From: Charlotte Burrows
Sent: 29 August 2014 09:34
To: [REDACTED]
Subject: 5 Highcroft Crescent, Bognor - BR/200/14/HH

1:500 BLOCK PLAN

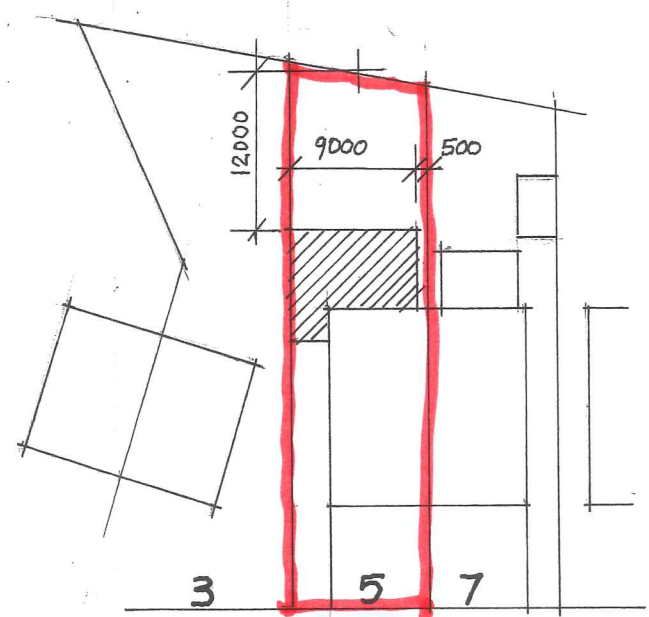
Unfortunately we still require two amendments to the Site/Block plan, we need the proposed works to be either hatched or highlighted and we also require the site dimensions from the dwelling to the site boundaries.
